**Andrew Beattie - MP09\_0049 MOD 1 - M2 Motorway Upgrade MOD 1 - Lane Cove Road On-Ramp - Ku-ring-gai Council submission**

Ku-ring-gai Council submission to  
Modification Request for M2 Motorway Upgrade  
Lane Cove Road On-Ramp  
MP09 - 0049 MOD 1

Figure 9 – Corridor on Lane Cove Rd for LinSig intersection performance analysis

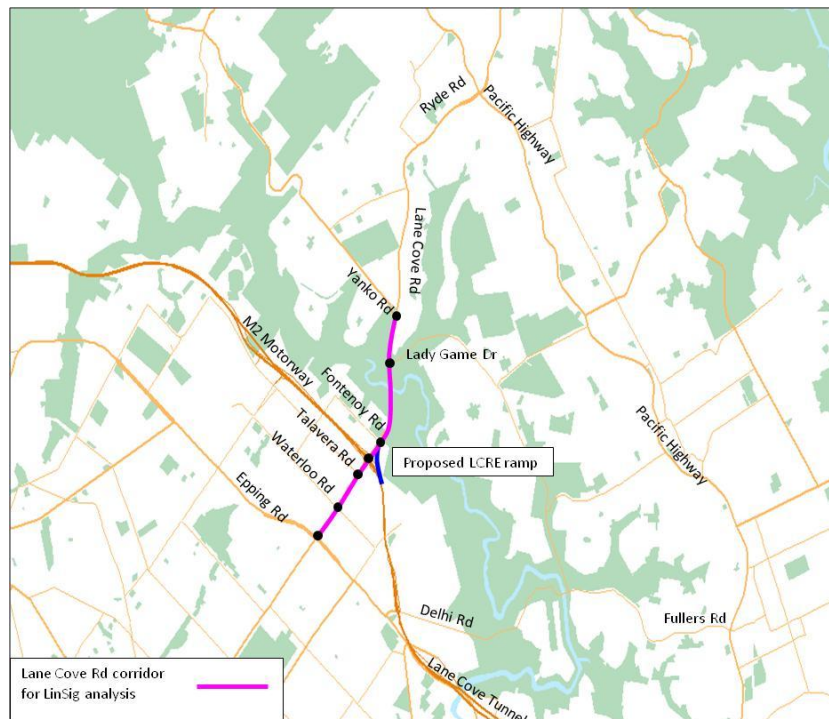
While the overall Level of Service of the intersection of Ryde Road with Lady Game Drive and Yanko Road are expected to deteriorate marginally (p37, Traffic and Transport Impact Assessment), this will have significantly higher impacts on the side roads (i.e. Lady Game Drive and Yanko Road) particularly in the am peak. This would result in increased delays and queue lengths and therefore travel time for vehicles travelling on Lady Game Drive and Yanko Road towards Ryde Road. Ku-ring-gai Council will be placed under further

Figure 12 – Re-directed route for pedestrians after closure

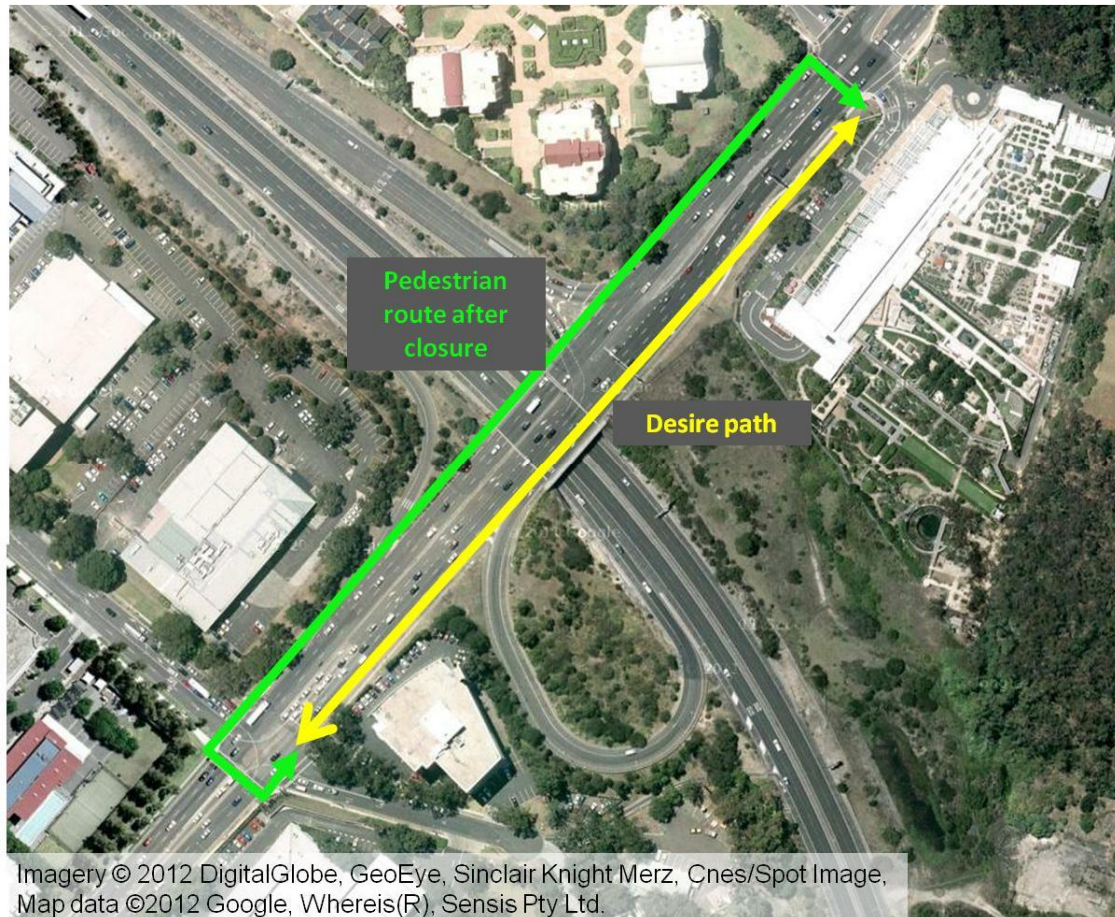
Ku-ring-gai Council would strongly oppose the proposal to close pedestrian access on the southern/eastern side of Lane Cove Road (between Fontenoy Road and Talavera Road).

Closing pedestrian access on the southern/eastern side of Lane Cove Road would interrupt the continuity of access (particularly if the destination is on the southern/eastern side of Lane Cove Road), as well as jeopardise any plans Ryde City Council may have for improving pedestrian and cycle connectivity in the area.

The proposed detour is considered to be significant in terms of pedestrian travel times. Faced with this additional delay, pedestrians are likely to try to

take the shortest travel path anyway, which would be across the proposed on-ramp and past the existing on-ramp.

Pedestrian facilities could be accommodated in the same way as they are currently accommodated across the westbound entry ramp to the M2 Motorway, or alternatively through traffic signal control. It is likely that existing pedestrian numbers are low on the southern/eastern side of Lane Cove Road between Fontenoy Road and Talavera Road due to a lack of footpath and crossing facilities, and completing the missing sections of footpath on the Ryde LGA side as well as formal pedestrian crossing facilities, would encourage better connectivity.
